Item No. **Report of the Head of Planning, Transportation and Regeneration**

Address 19 LAWN AVENUE WEST DRAYTON

Development: Part two storey, part single storey side/rear extension

LBH Ref Nos: **75358/APP/2020/4075**

Proposed Elevations

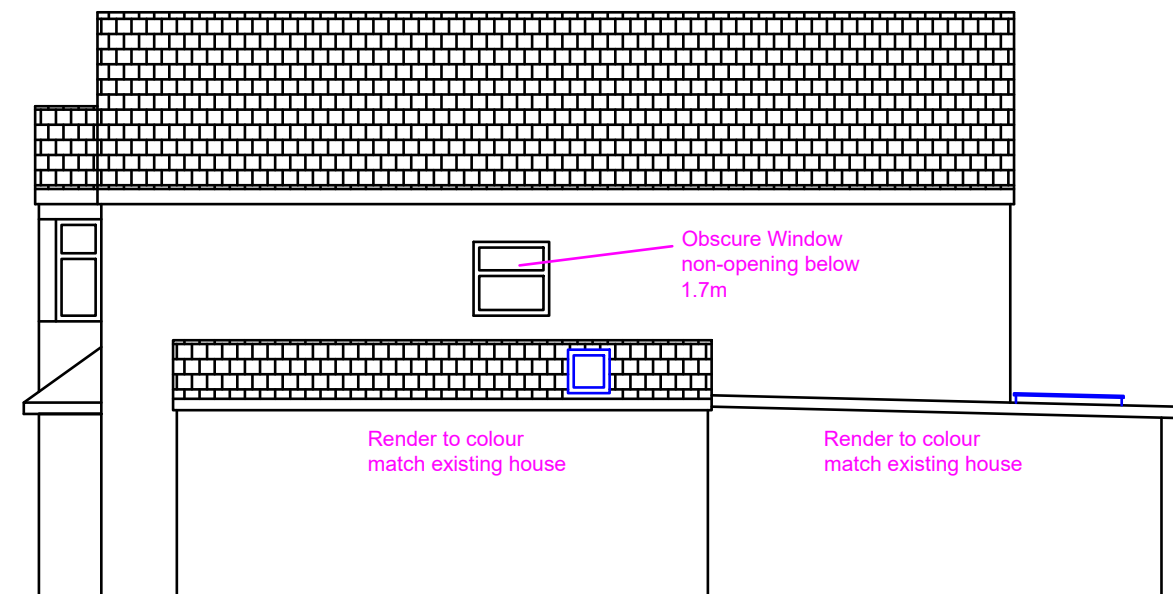
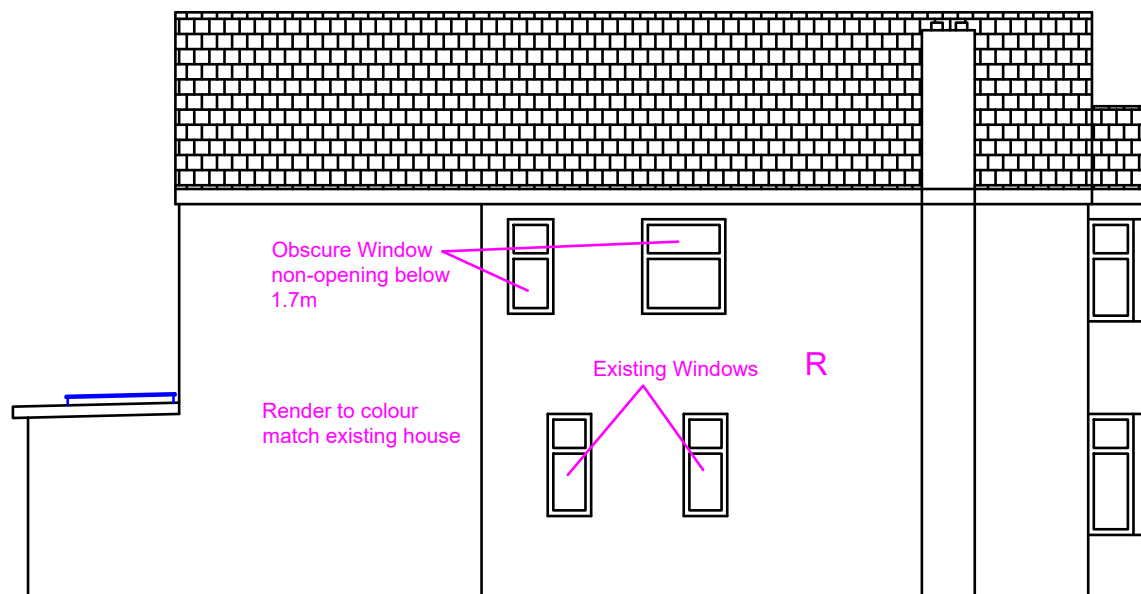
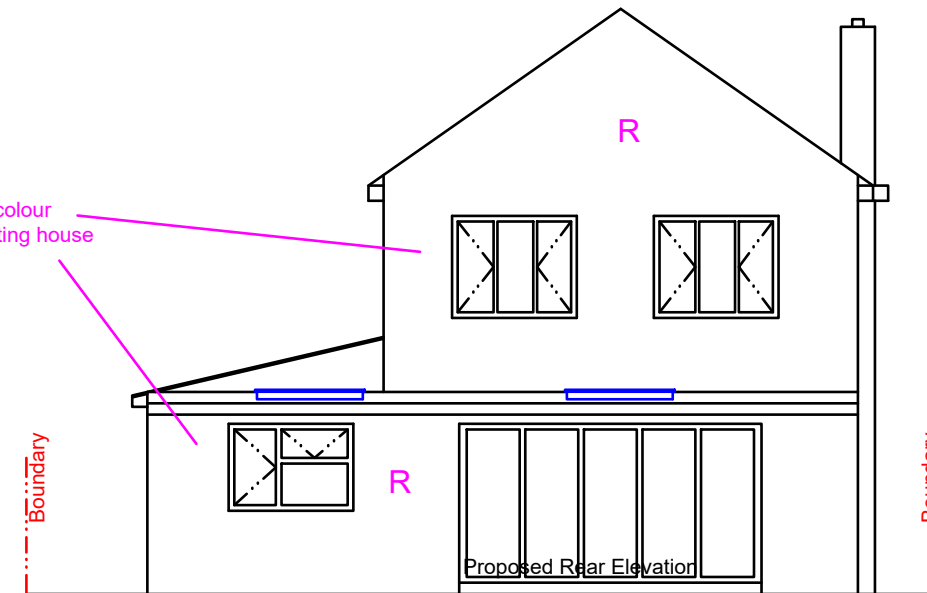
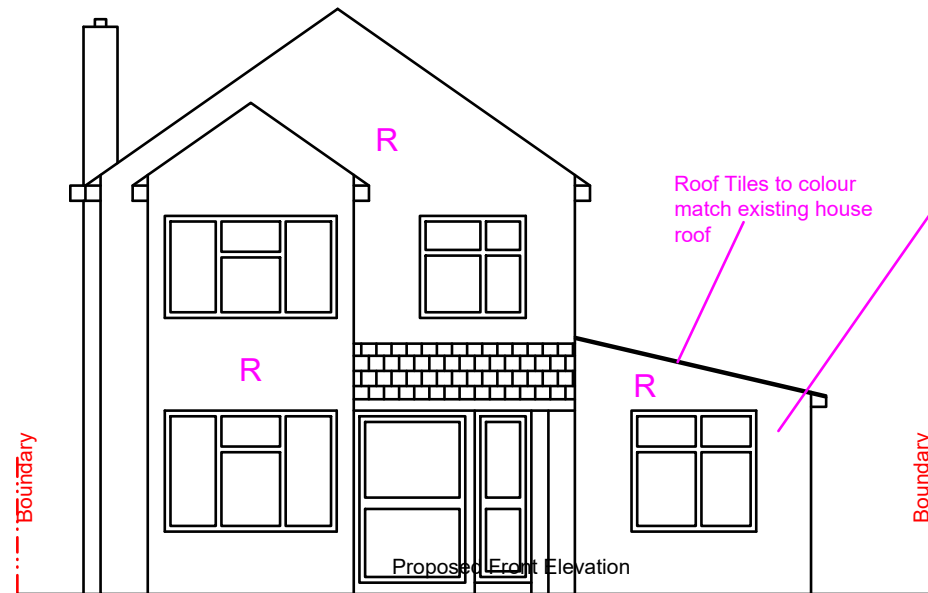
It is duly noted that the property has benefitted from approval for a side addition at ground floor. The proposed development would go further by adding a built mass at first floor. Whilst in isolation the cat-slide roof design would limit the bulk of the addition, the effect would be entirely diminished by the proposed side box-dormer. The dormer would extend for the full length of the existing dwelling and approved depth of the first-floor rear extension. It would be considered an incongruous, unacceptable addition. It would fail to relate to the character and style of the existing property and wider ASLC. It would appear as a poorly

integrated built element and reduce the existing gap between the neighbouring site.

mass at first floor. Whilst in isolation the cat-slide roof design would limit the bulk of the addition, the effect would be entirely diminished by the proposed side box-dormer. The dormer would extend for the full length of the existing dwelling and approved depth of the first-floor rear extension. It would be considered an incongruous, unacceptable addition. It would fail to relate to the character and style of the existing property and wider ASLC. It would appear as a poorly integrated built element and reduce the existing gap between the neighbouring site.

The cumulative scale of the development proposed would not appear subservient to the host dwelling and would result in an elongated and flat roofed side dormer within the flank elevation, which would not be in character with the existing property or the area in general. Given the spacing between properties and the height of the adjoining property, the side dormer roof design would be very visible. Whilst the houses in this road show a great variety of shapes, sizes and roof forms, the proposed scheme would appear unacceptable within the street scene, as it would fail to appear less subservient to the host dwelling. Consequently, the proposal would fail to harmonise with the local context by taking into account the surrounding scale of development, considering the scale, mass and bulk of adjacent properties.

The proposal, therefore, by reason of its size, scale, bulk, width and design would fail to appear as a subordinate addition and would thus fail to harmonise with the architectural composition of the original dwelling and would be detrimental to the character, appearance and visual amenities of the street scene and the surrounding Garden City, West Drayton Area of Special Local Character. The proposal is therefore contrary to Policies BE1 and HE1 of the Hillingdon Local Plan: Part One - Strategic Policies (November 2012), Policies DMHB 1, DMHB 5, DMHB 11 and DMHB 12 of the Hillingdon Local Plan Part Two - Development Management Policies (January 2020), Policy 7.8 of the London Plan (2016) and the NPPF.
